Recommendation Report for Planning Permission for Works or Extension to a Dwelling

REF NO: M/93/25/HH

LOCATION: 26 West Close
Middleton-on-sea
PO22 7RP

PROPOSAL: Single storey rear extension and first floor side and rear extensions

Front Elevation (Proposed)
Scale 1:100

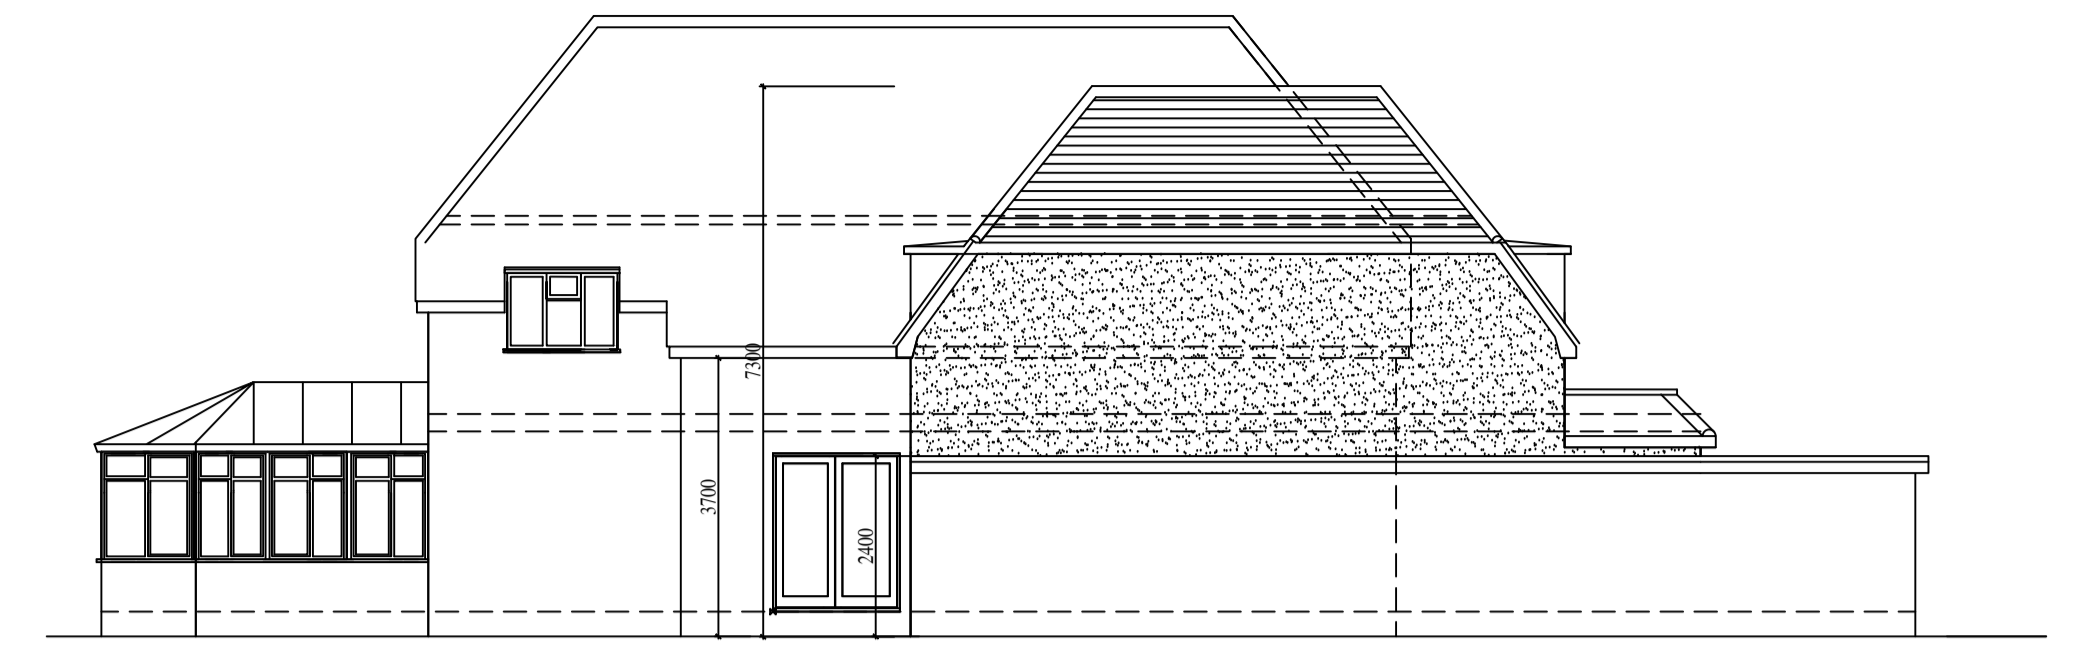
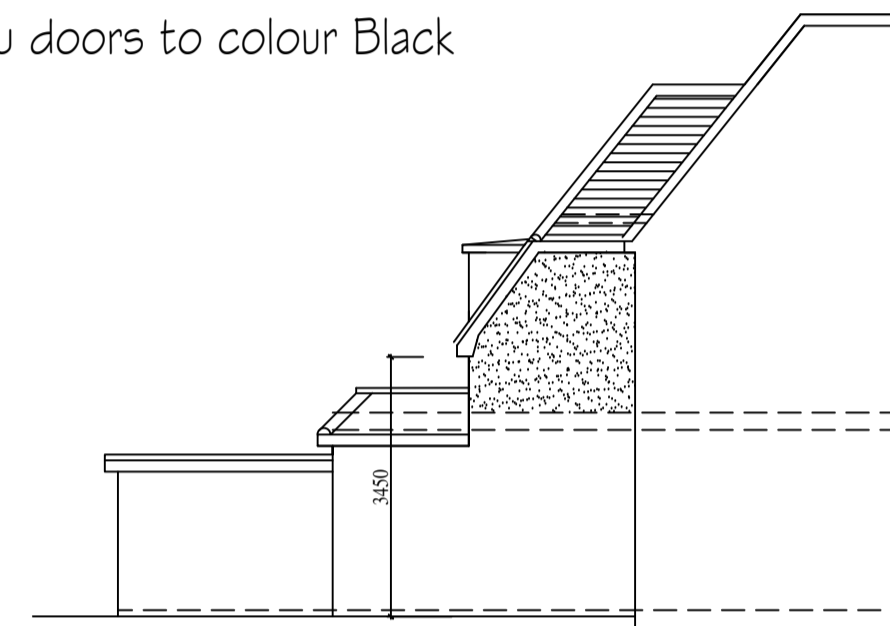
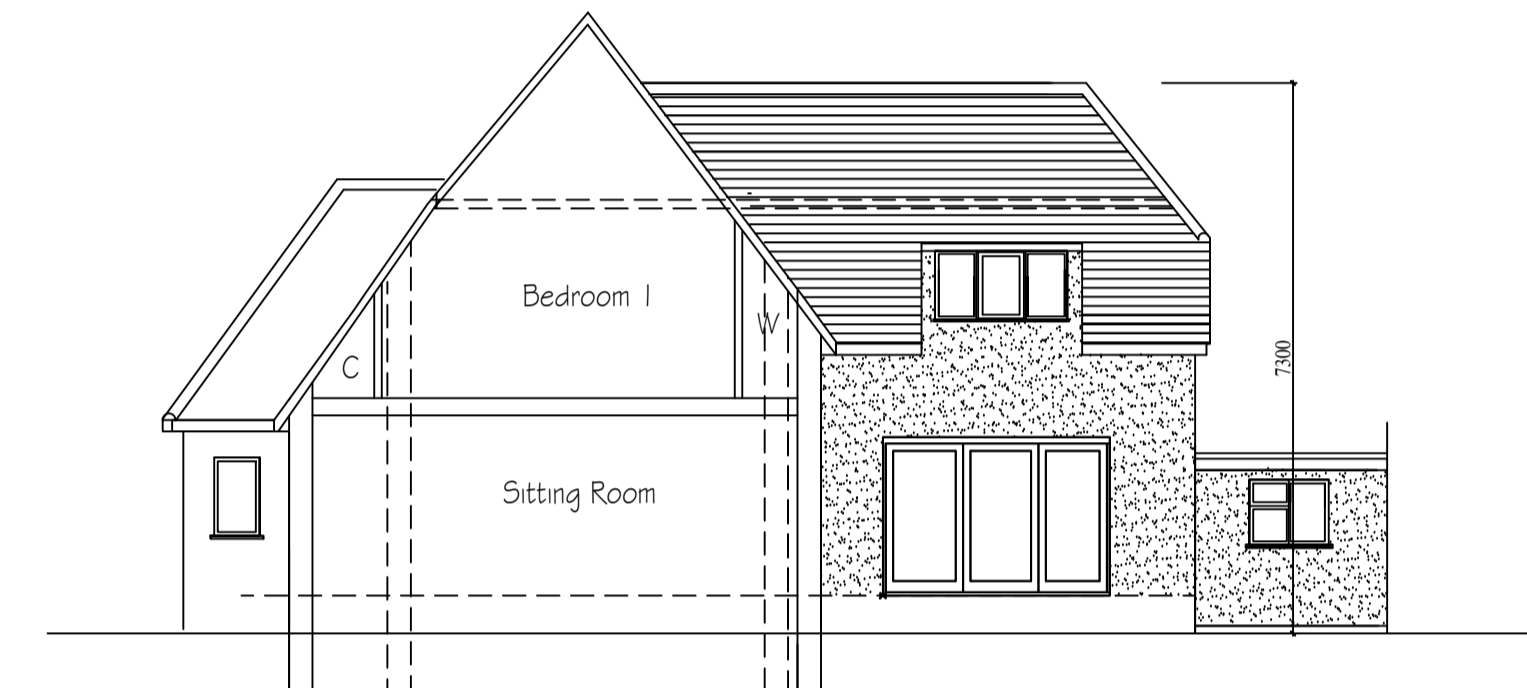
The Arun Design Guide (ADG) outlines that the first-floor element of the extension should be set back by more than 2m from the front elevation of the existing dwelling. The proposed extension would comply with this guidance. This setback helps to retain the original form and visual dominance of the host property when viewed from the street. In addition, the roof of the extension would be set down from the main ridge by an excess of 0.5m, ensuring that the extension would be a subservient addition rather than an overbearing or dominant feature. These design features allow sufficient visual separation between buildings to be maintained and prevent the creation of a terracing effect along the street, thereby preserving the openness of the surrounding area. Overall, the scale, form and design of the extension reflect the established character and appearance of the existing dwelling, enabling it to sit comfortably within the street scene without appearing incongruous. The proposal would not result in harm to the character of the dwelling or the wider area and is in accordance with Arun Local Plan policies D DM1 and D DM4.

The proposal also incorporates a first-floor side extension measuring approximately 3.9m in depth and 2.3m in width, aligned with the existing front elevation of the dwelling. While this element does not fully accord with the ADG guidance that encourages first-floor extensions to be set back from the front elevation, the extension would be stepped down from the main ridge line of the host dwelling and would be modest in its proportions, ensuring that it would remain visually subservient to the host dwelling. As a result, this element would not appear prominent when viewed from the street and would not detract from the character or appearance of the host dwelling or the surrounding street scene. The proposal is therefore considered acceptable in design terms despite the minor departure from guidance. The proposed extension is therefore in accordance with Arun Local Plan policies D DM1 and D DM4.

The two-storey part of the extension would marginally breach a 45-degree splay line when measured from the rear windows of the neighbouring property to the east. However, the extension would be set in from the shared boundary and relates to the existing scale and form of the dwelling. While some limited overshadowing of the neighbour's rear garden is likely to occur, this would be minor and would not result in unacceptable harm.

Additional windows are proposed on the north and south elevations. The first-floor window on the southern elevation would look over the application site frontage. Whilst some oblique views of the neighbouring garden to the east would be available, it is noted that the host dwelling has existing first floor fenestration facing this neighbour, and as such, the proposed fenestration within the southern elevation would not result in harmful overlooking. Windows on the northern elevation would have a similar outlook to existing openings and would not introduce any new overlooking concerns.

Ground Floor Plan (Proposed)
Scale 1:100

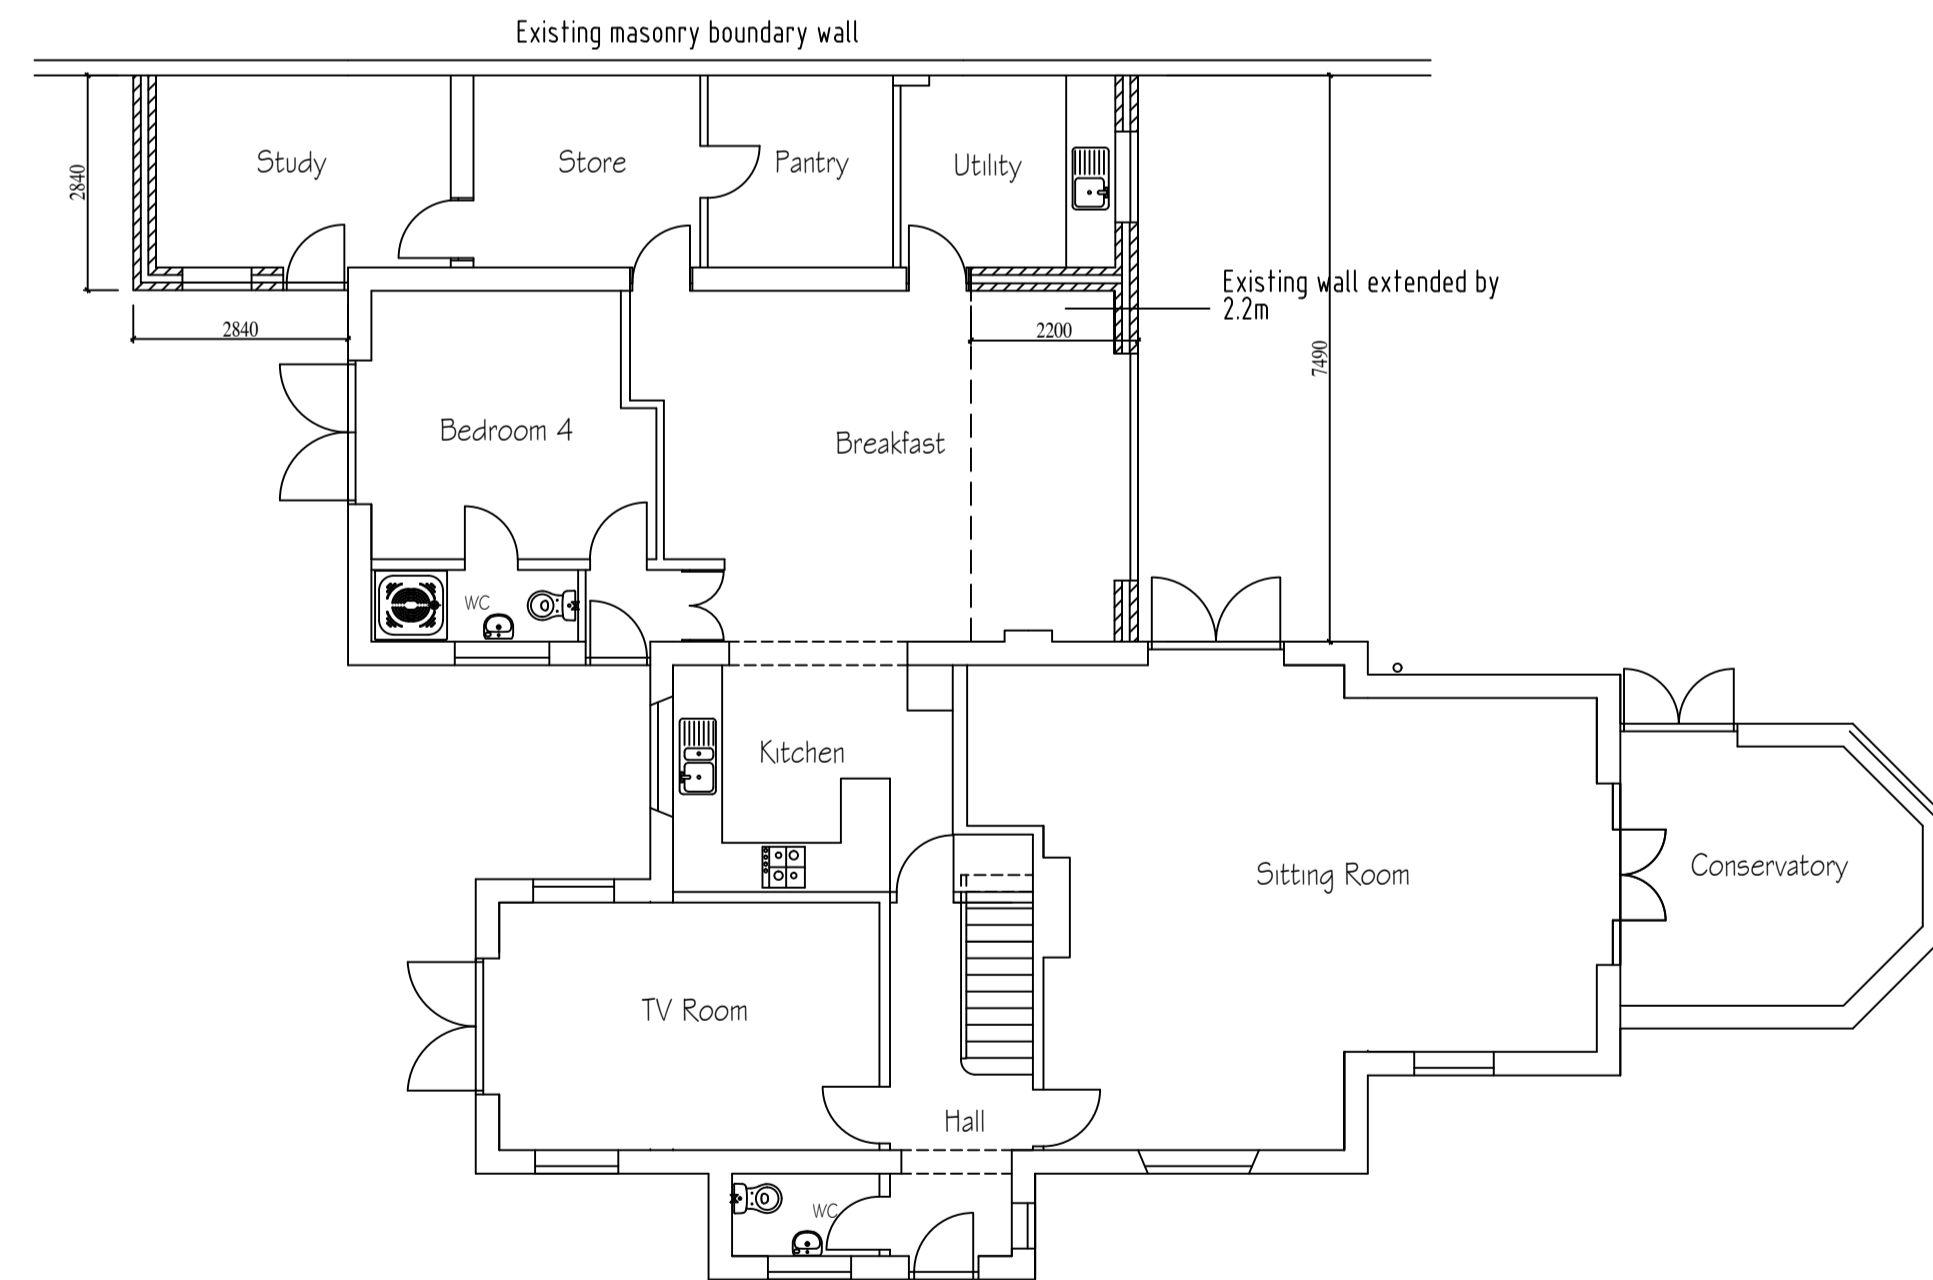
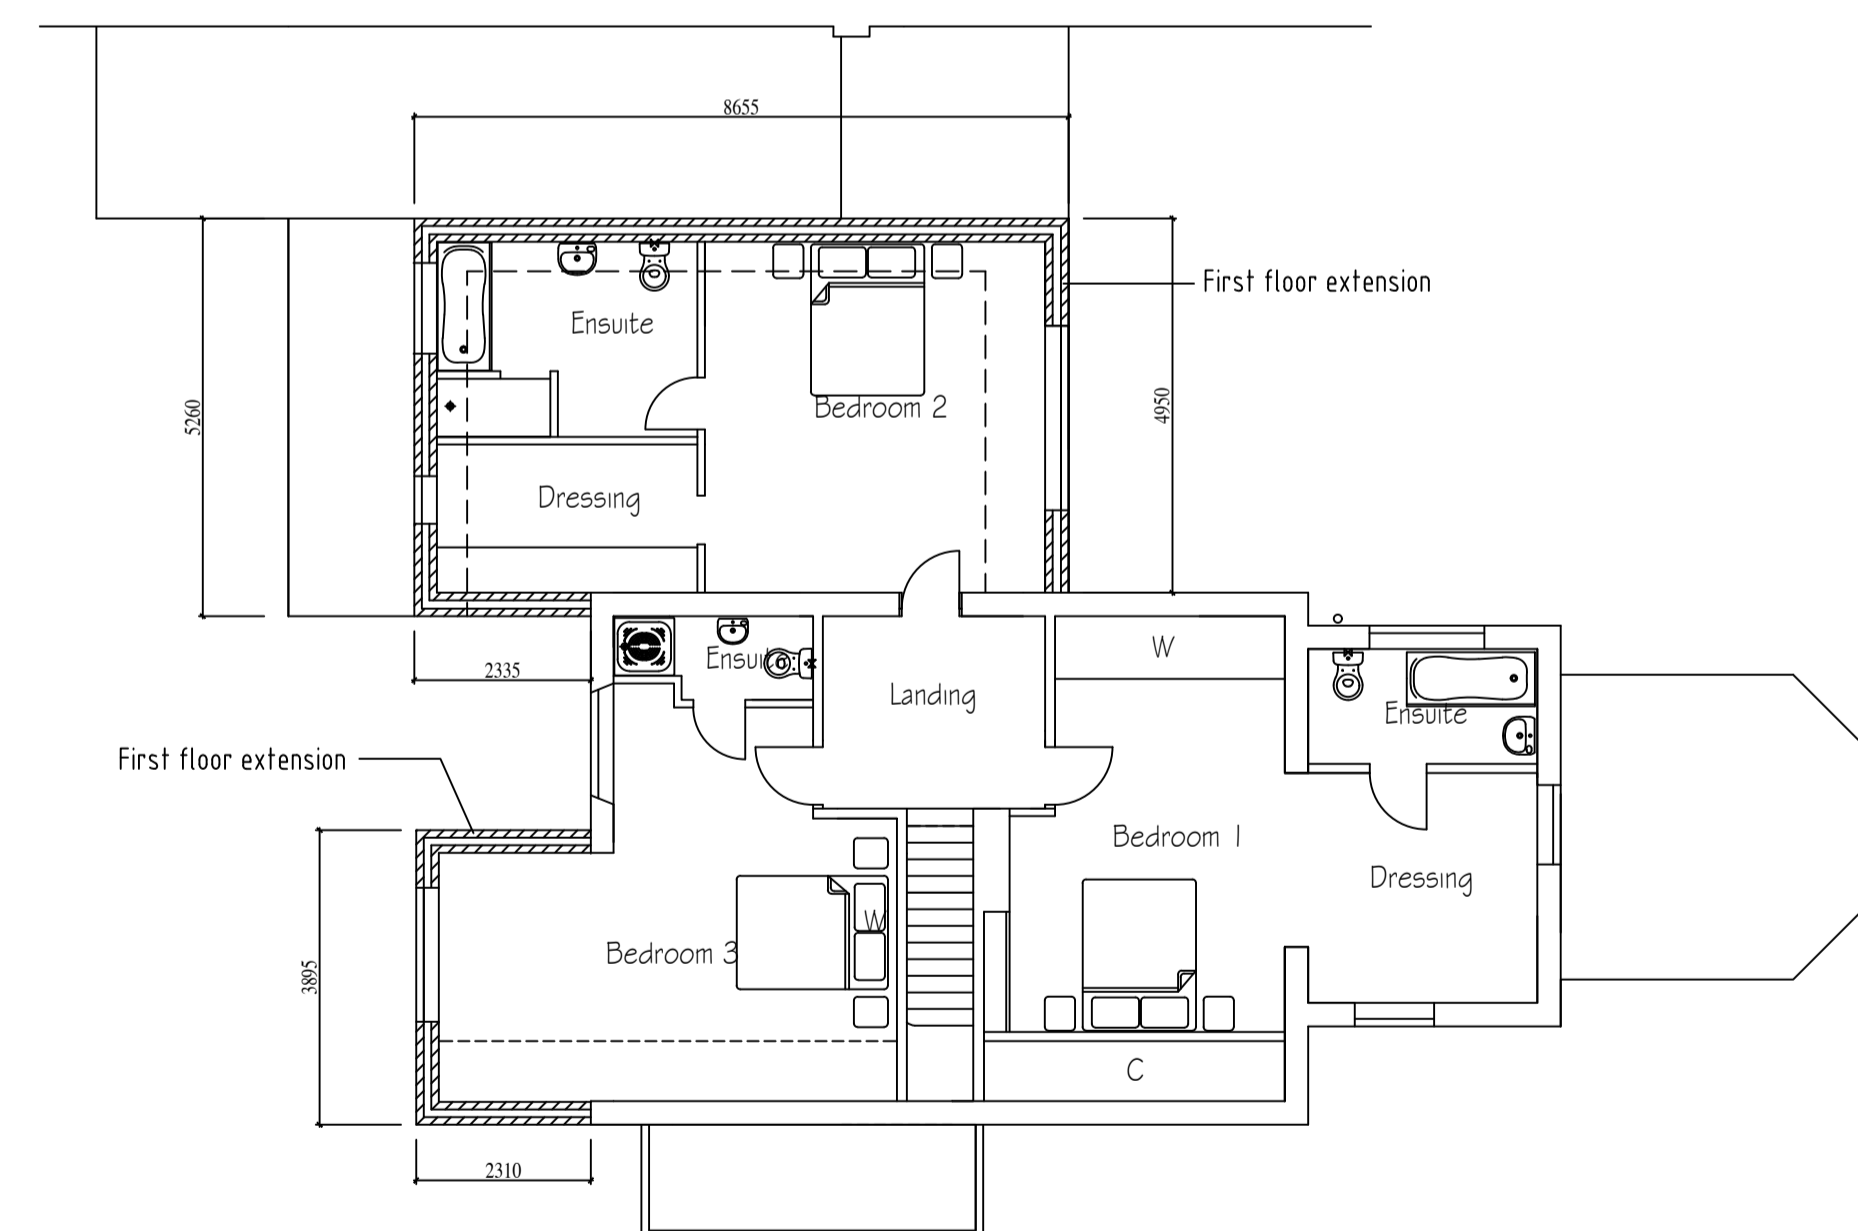
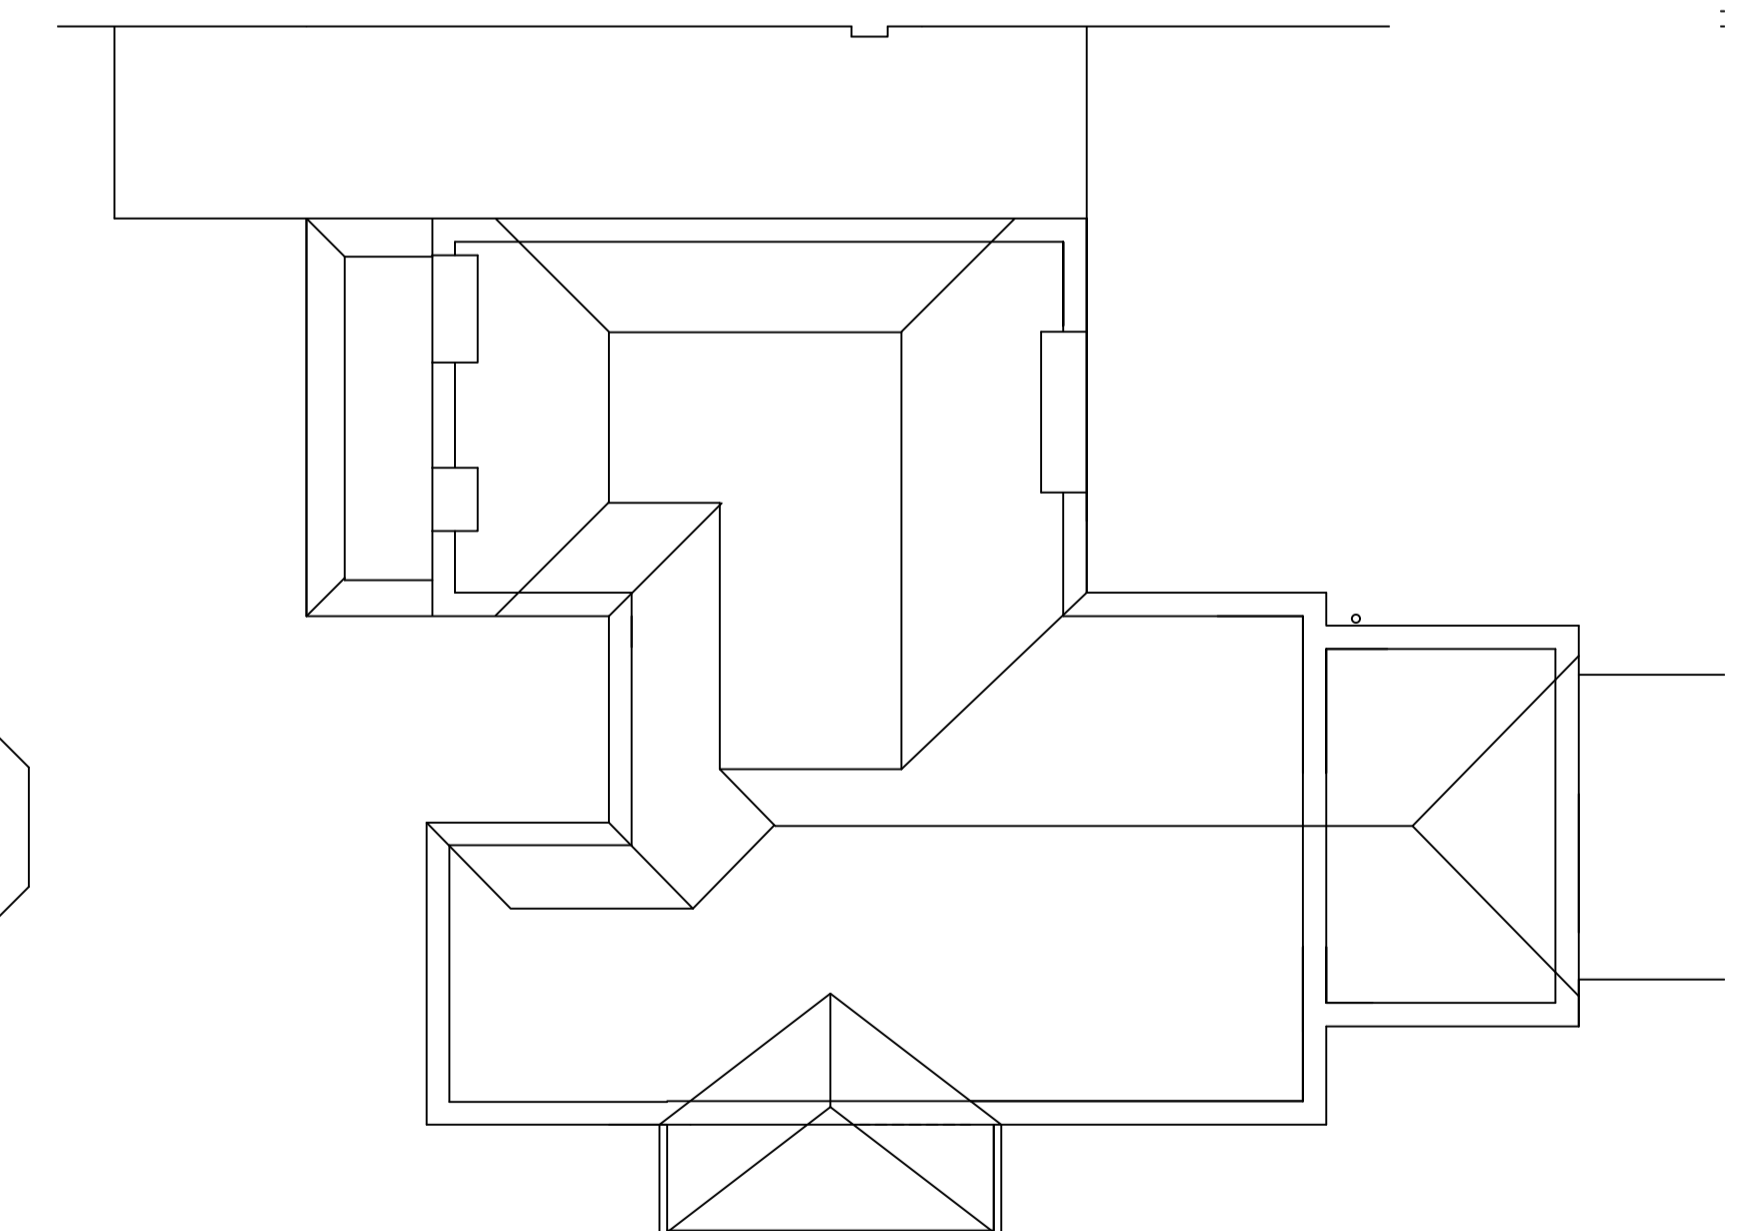
Drainage Engineers - Objection on the basis of:

- Insufficient information has been provided.
- The application proposes to manage surface water on site via a new soakaway and permeable paving. This is acceptable in principle, as infiltration is the highest priority in the drainage hierarchy and aligns with Standard 1 of the Non-Statutory Technical Standards for SuDS (NSfS).
- Insufficient evidence has been provided to demonstrate that infiltration is a viable solution. Without it, it is not possible to assess whether the proposed development would increase flood risk. Ground conditions and infiltration potential in Middleton-on-Sea are highly variable. While infiltration may be feasible in some areas, others experience high groundwater levels or poor infiltration rates that render it unviable.

that the Drainage Engineers have raised an objection to the proposal, noting that the application indicates that surface water from the extended dwelling would be managed via soakaways. While the use of soakaways would generally be supported in principle, no supporting evidence has been submitted to demonstrate that infiltration is feasible at the site. It is also recognised that ground conditions and infiltration potential within the Middleton area can be variable.

The public sewer in the Lidsey Wastewater Treatment Catchment Area has a history of flooding and any surface water added to this system should be assumed to increase flood risk.

However, the proposed development would not introduce additional surface water pressure beyond existing conditions. The proposed ground floor extensions would be constructed over areas of existing hardstanding, while the proposed first-floor extensions would be built entirely over the existing footprint of the dwelling. As a result, the development would not lead to an increase in impermeable surface area or generate additional surface water runoff when compared to the existing situation. On this basis, the proposal would not result in an increase to the risk of flooding on or off site, having regard to the scale of development and the absence of any increase in hard surfacing.

Given that the development would extend over existing built form and existing hardstanding, a refusal on drainage grounds would not be reasonable in this instance. The proposals would not increase flood risk elsewhere, in accordance with Arun Local Plan policies W DM1 and W DM3.
